**CITY OF ALBUQUERQUE
PLANNING DEPARTMENT
April 23, 2014
DRB Comments**

PROJECT # 1010046

APPLICATION # 14-70103

RE: Lots 10-12, Block 1, Westpark Addition

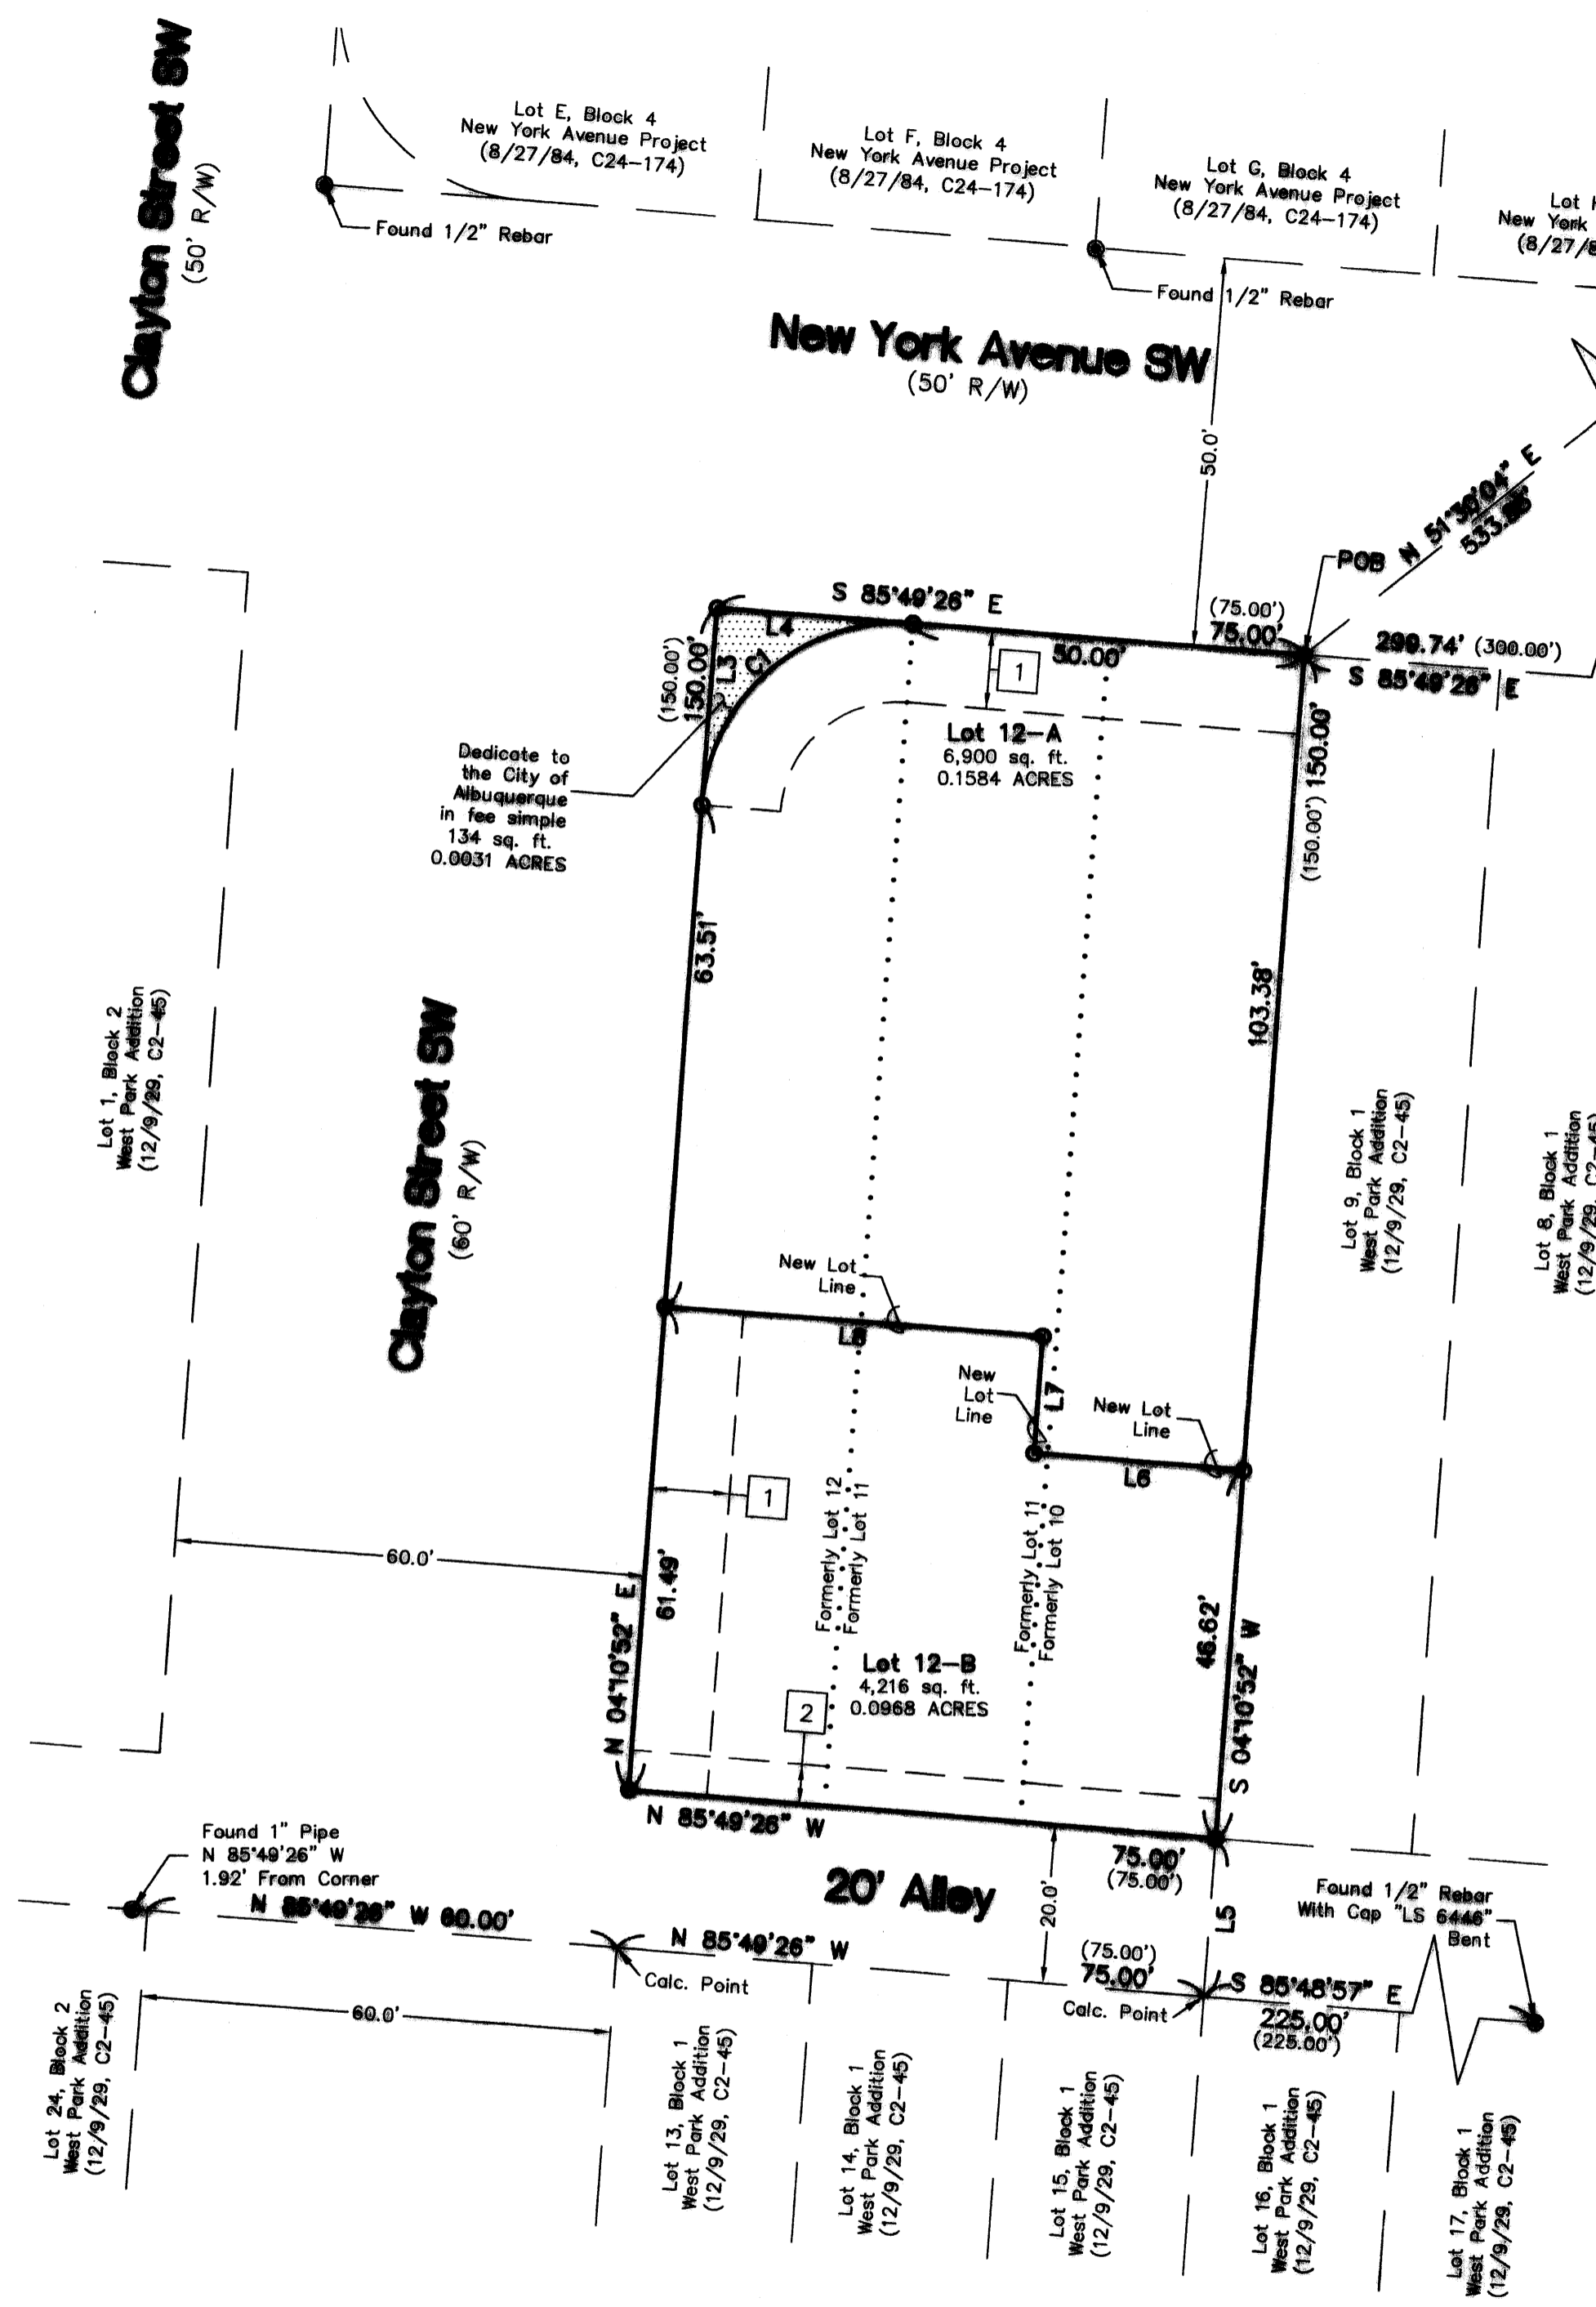
In order to comply with the Subdivision Ordinance to “meaningfully decrease the degree of already existing nonconformity” the proposed Lot 12-B needs to be as uniform [“squared”] and close to the minimum lot area [5,000 sq ft] as possible, therefor the ‘notch’ should be removed.
